Rezoning Transportation Analysis

Petition Number: 2021-178

Date	Description
11/21/2021	First Review (PDM)
12/20/2021	Second Review (PDM)
01/27/2022	Third Review (PDM)

SHEET NUMBER:
RZ-1

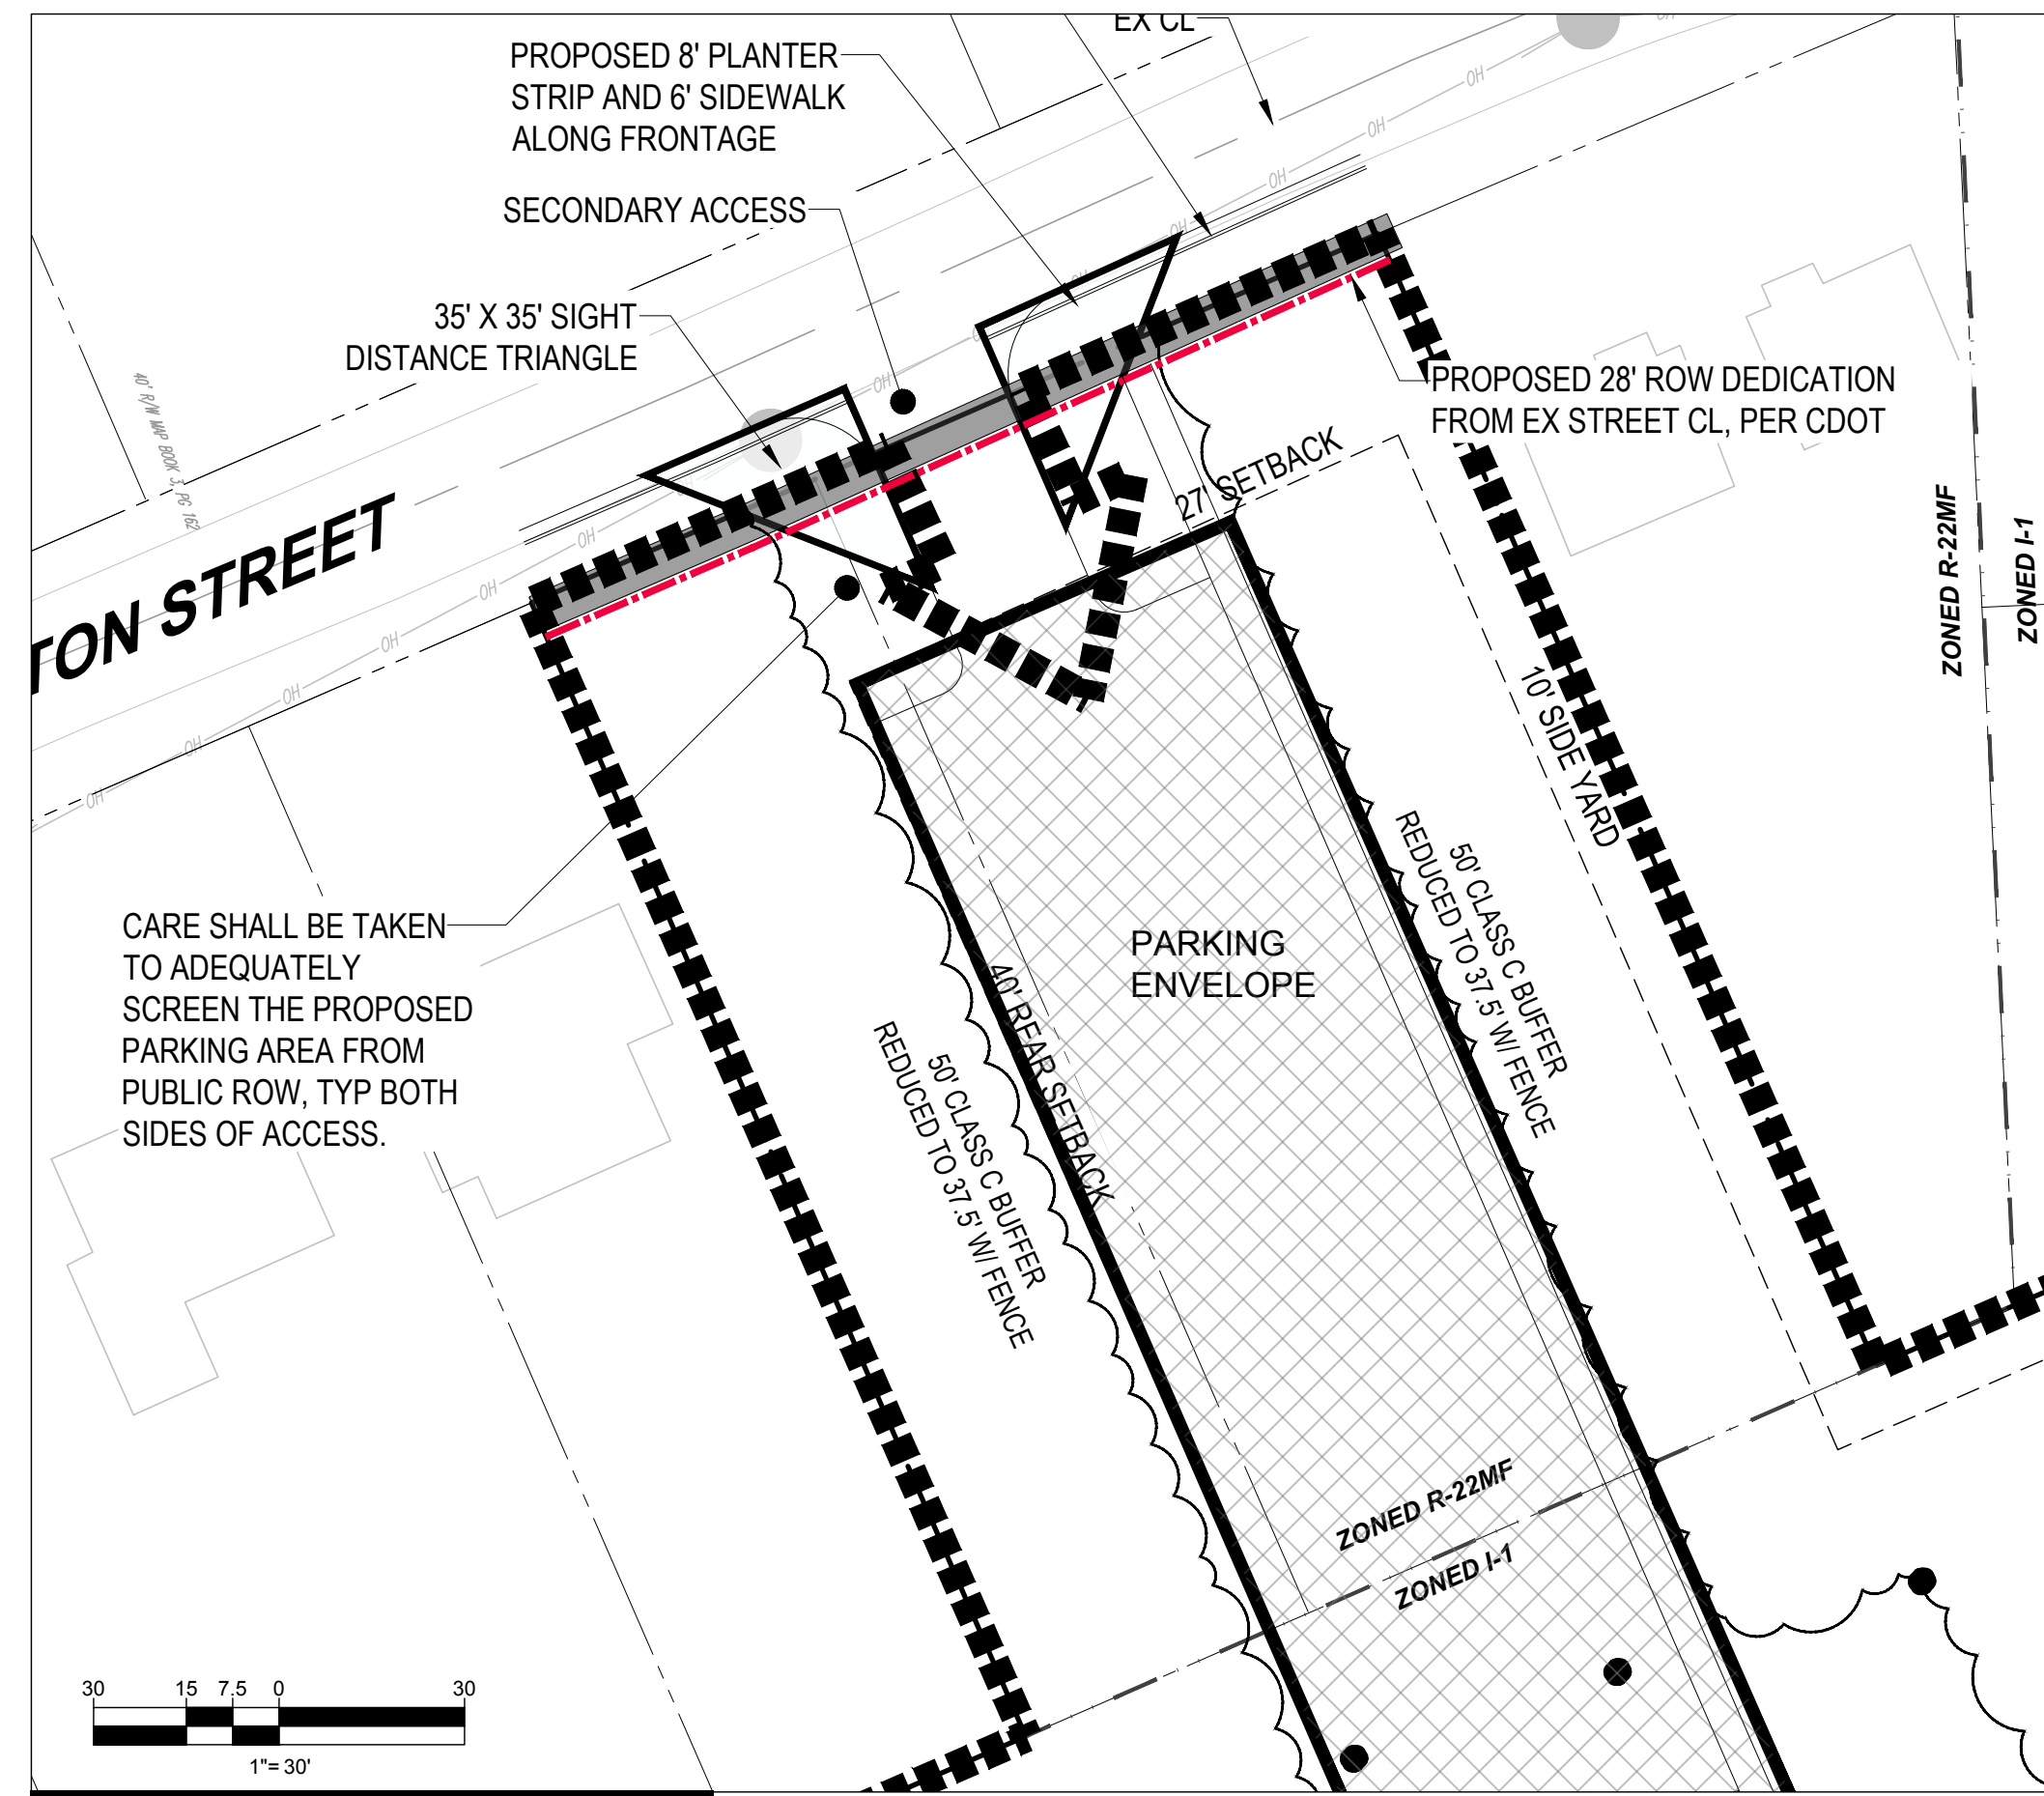
Label and dimension the curb and gutter from the centerline for each road on the site plan.
2. **Traffic Study: (Choose One)**
~~A Traffic Impact Study (TIS) is not necessary for the complete review of this petition due to the site generating less than 2,500 daily trips. If during the permitting process the site generates more than 2,500 daily trips, then a traffic study will be required.~~

11. **Outstanding Comments from 11-21-21:** Revise site plan and conditional note(s) to commit to installing a local residential median street per CLDSM U-02 (**Request**) or a 12-foot multi-use path (**Required**) connecting Whittington Street to Julia Avenue.

Clarifying Comments from 1-27-22: Extend MUP to Whittington Street. MUP needs to tie into the existing street. Dedicate ROW, SUE, or provide public access easement for the MUP.
